Re: PA22-040 – 87th & 40th PRD – Technical Review 2
4218 / 4112 / 4018 / 3922 / NNA 87th Ave NE

After preliminary review of the above referenced proposal, the following comment(s) are provided:

SHEET	OF
C7.21	30

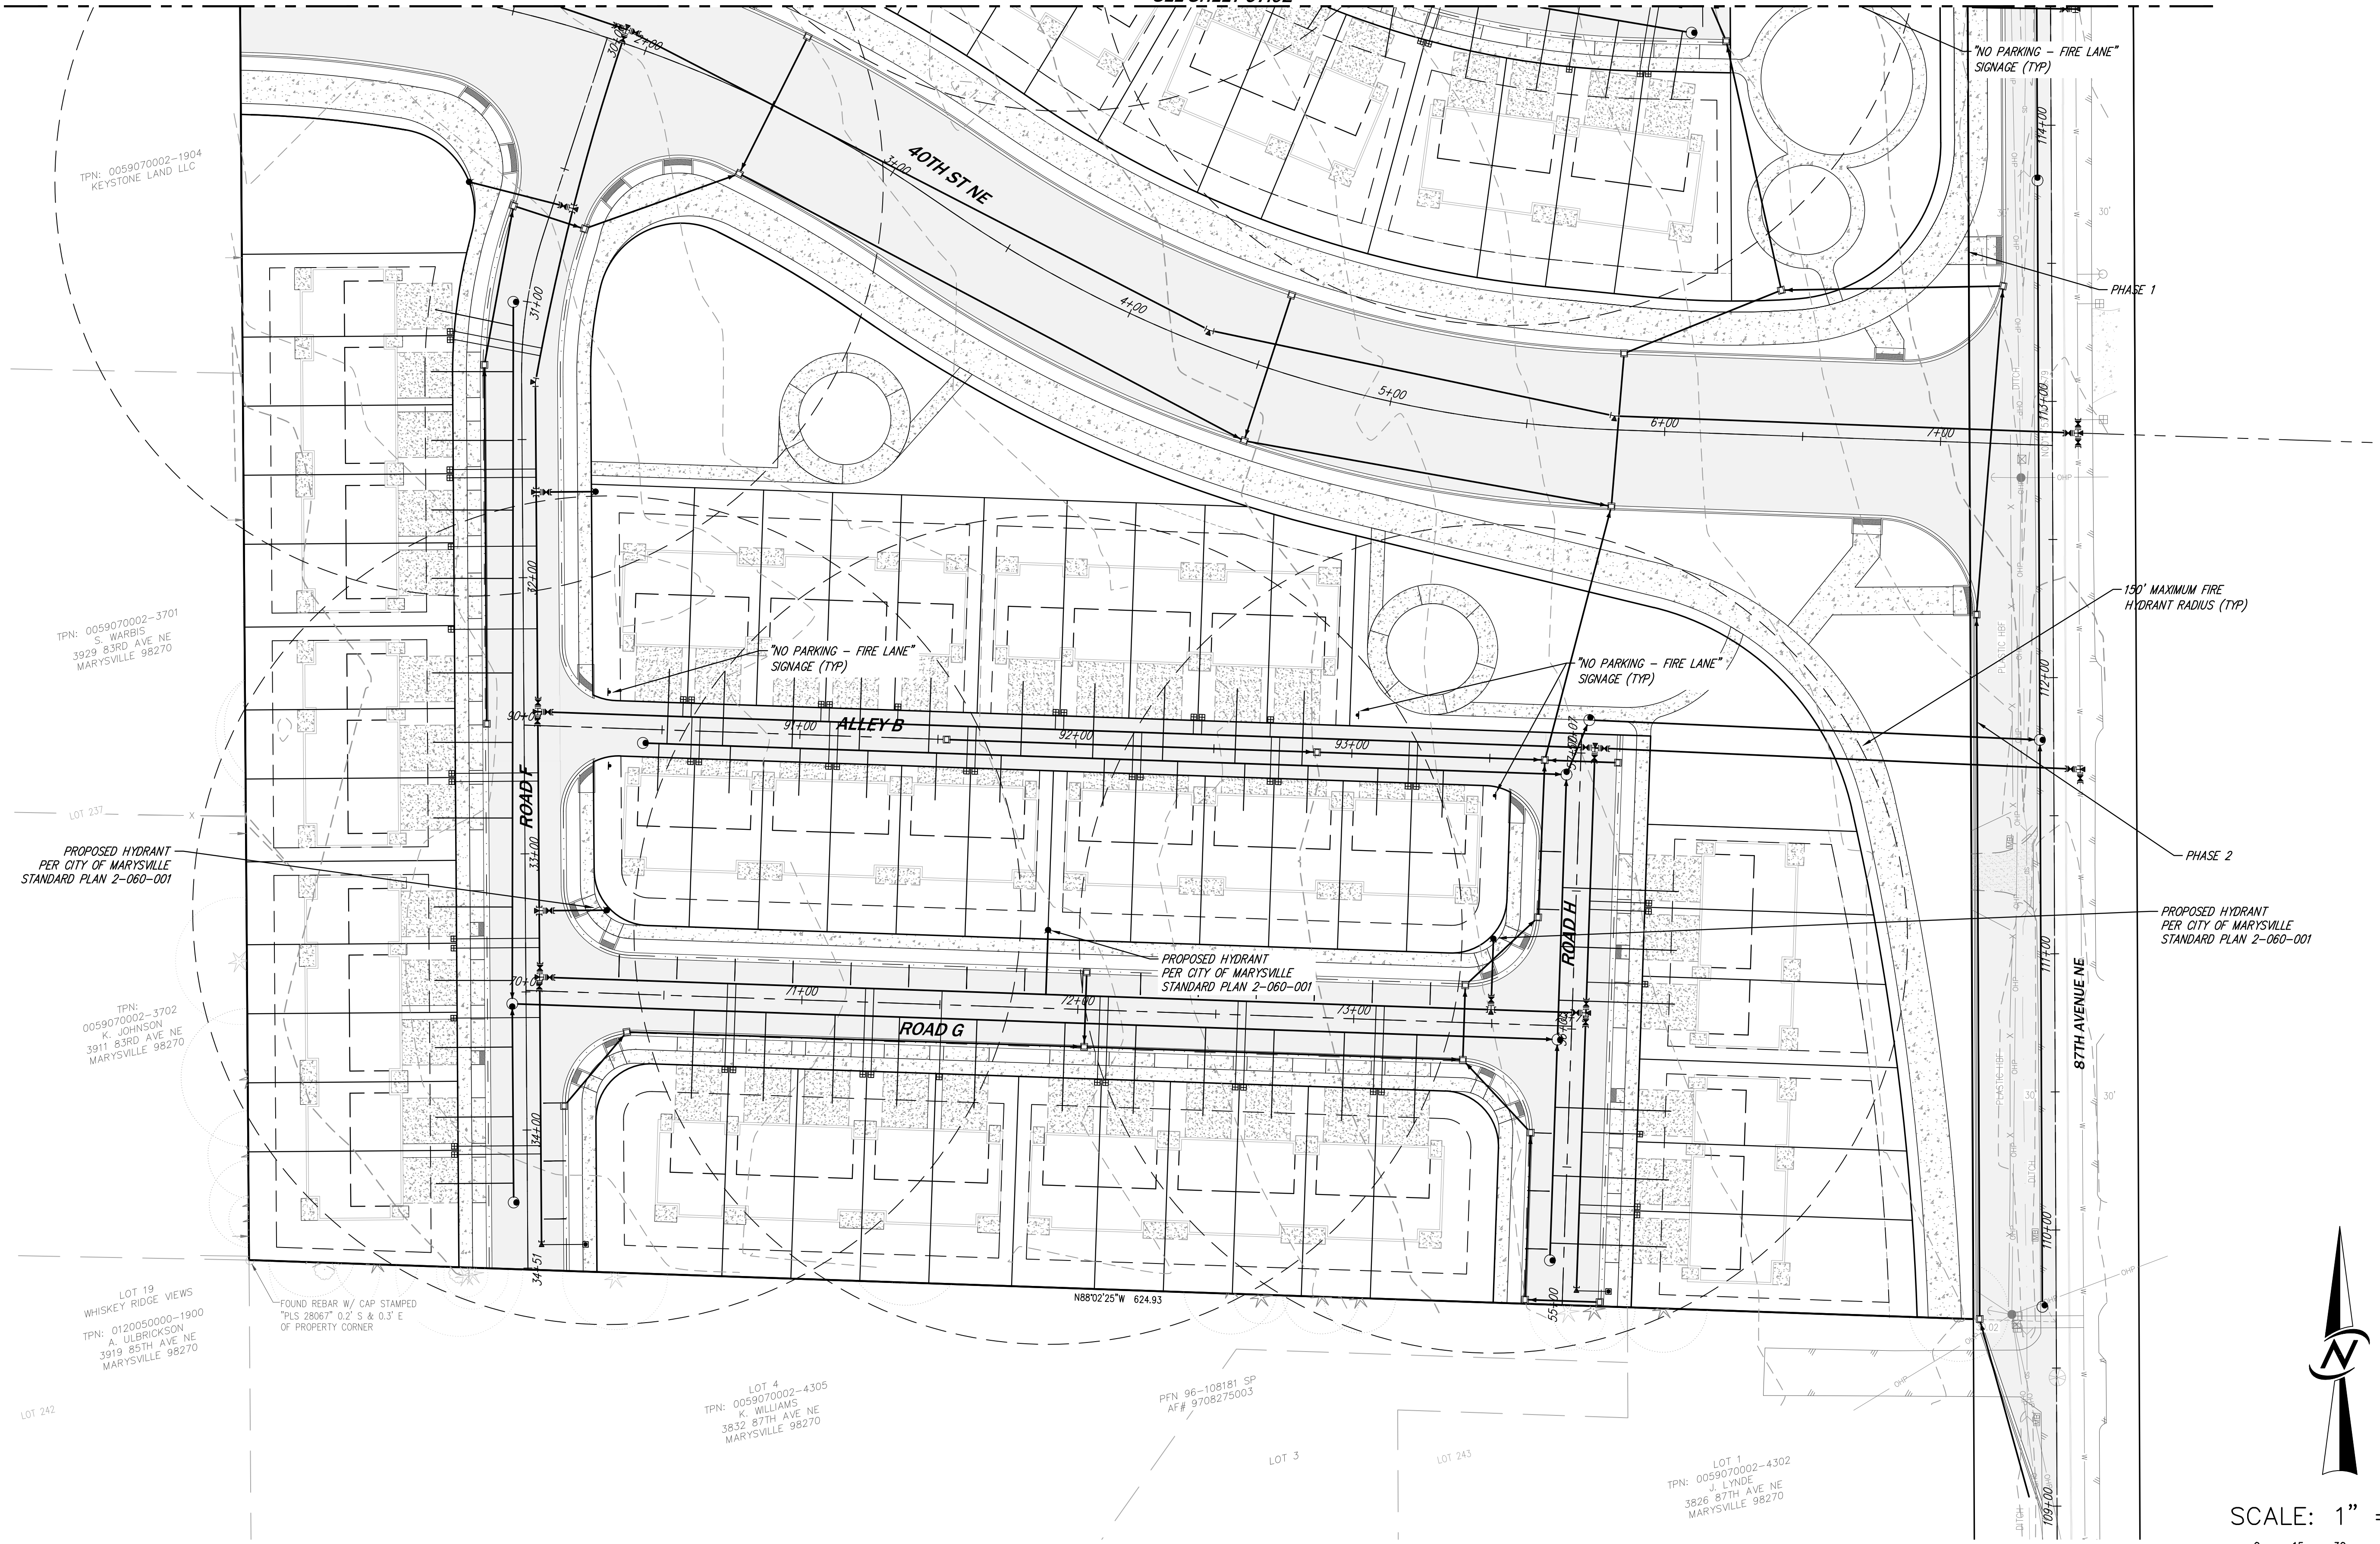
3. **HYDRANTS** – additional hydrants need to be installed at the following locations:
 - 3.1. At the intersection of 40th St and Road F – SW corner preferred.
 - 3.2. Midway down north section of alley A, near lot 131.
 - 3.3. Midway down south section of alley A, near lot 120.
4. **ACCESS** - Signage stating “NO PARKING – FIRE LANE” needs to be installed on both sides of any 20’ wide roadway.
